**From:** Bloomer, David <David.Bloomer@lancashire.gov.uk>  
**Sent:** 12 July 2018 13:46  
**To:** Harriet McCartney  
**Cc:** LHS Customer Service; planning  
**Subject:** app3/2018/0349 Fleet Street Garage, Ribchester

FLEET STREET GARAGE

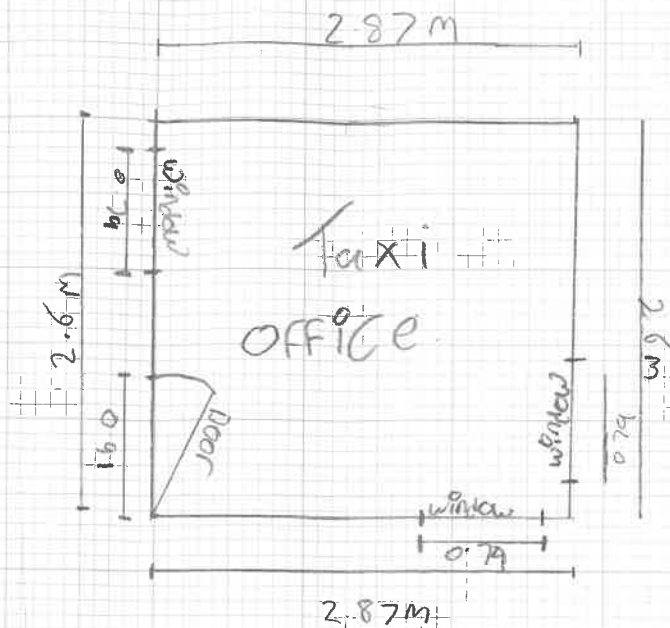
Unfortunately the application doesn't contain sufficient details for me to fully consider the proposal. In order to do so I would need to know the following

1 How many vehicles will be operating from the site?

2 The designated parking area for these vehicles will need to be shown on a scaled plan of the whole site. I need to be satisfied that this additional parking will not interfere with the primary use of the site. The access and egress of coaches etc
